**Black Sluice
Internal Drainage Board**

EN10123 Heckington Fen Solar Park

Response to The Examining Authority's written questions and requests for information (ExQ1) issued on 17 October 2023

04 December 2023

**WATER BODIES IN A RIVER BASIN MANAGEMENT PLAN**

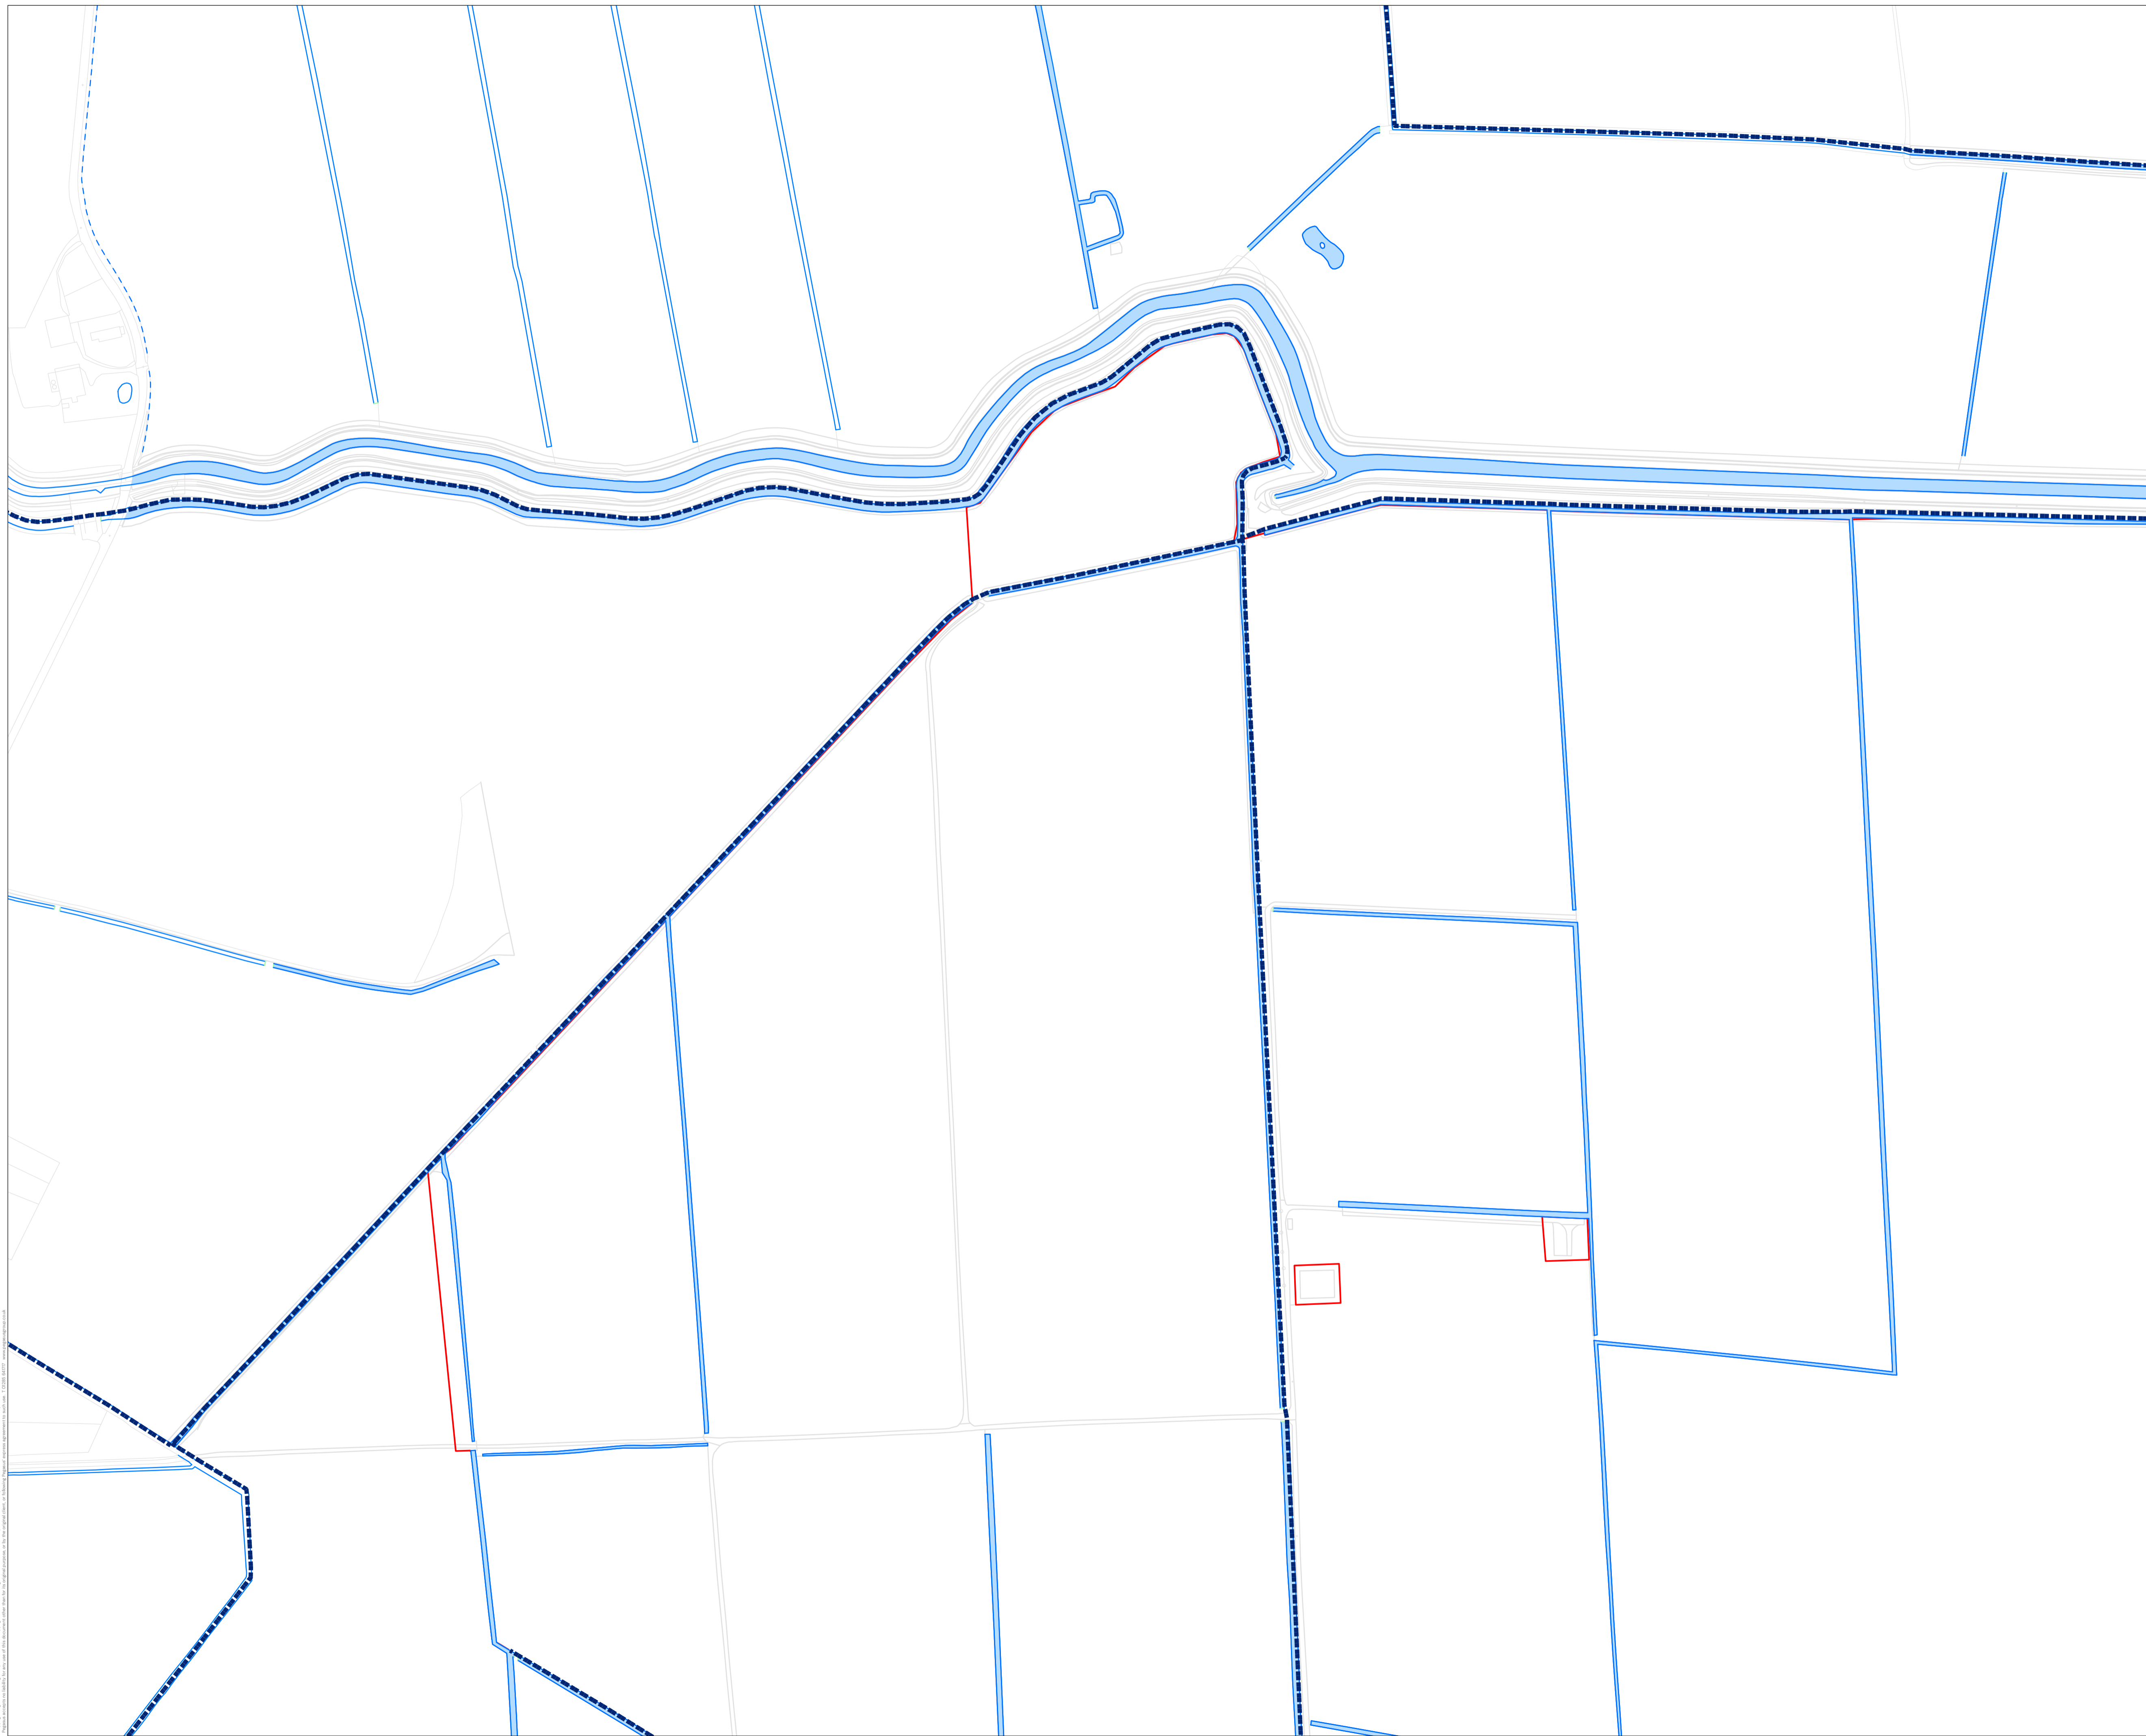
12. WATER ENVIRONMENT & FLOOD RISK		
WE.1.4	<p>Water Bodies in a River Basin Management Plan [PS-017] shows the range of watercourses which cross the Order Land and in the surrounding area, many of which will need to be crossed by the Proposed Development.</p> <ul style="list-style-type: none"> i) Could the Applicant clarify how the directional drilling or similar technology under the IDB drains and other major wet drains would be controlled through the DCO process? ii) Could the IDB, the EA and Lead Local Flood Authority (LLFA) provide any further comments they wish to raise regarding the proposed methods of watercourse crossings and whether you consider the final details are able to be adequately secured by Requirement 6 of the dDCO [PS-024] alongside the protective provisions set out in Schedule 13 Parts 5 and 7. iii) For the smaller field ditches can the Applicant explain how these will be monitored for water retention and rainfall during construction to ensure that silt run off is minimised. <p>Could the EA, IDB or LLFA comment on the mitigation and monitoring measures.</p>	<p>i). This would be covered by applications for consent to the Board, as per Schedule 13 Part 7 Item 73 under the definition of “specified work”.</p> <p>ii). The Board is satisfied with the wording of the protective provisions in Schedule 13 Part 7.</p> <p>Mitigation & Monitoring - The Board will expect the Applicant to use silt retention facilities such as lagoons. If any water is to be discharged into any watercourse at any time, then the use of “silt-busters” or similar means of restriction will be expected to ensure that there will be no silt deposited in the receiving watercourses which would cause a blockage, whether within the order limits or without. Any silt discharged, either in an emergency or due to an infrastructure failure, will be the Applicant’s responsibility to rectify at their costs. This would include any adverse effects to land or property downstream.</p>
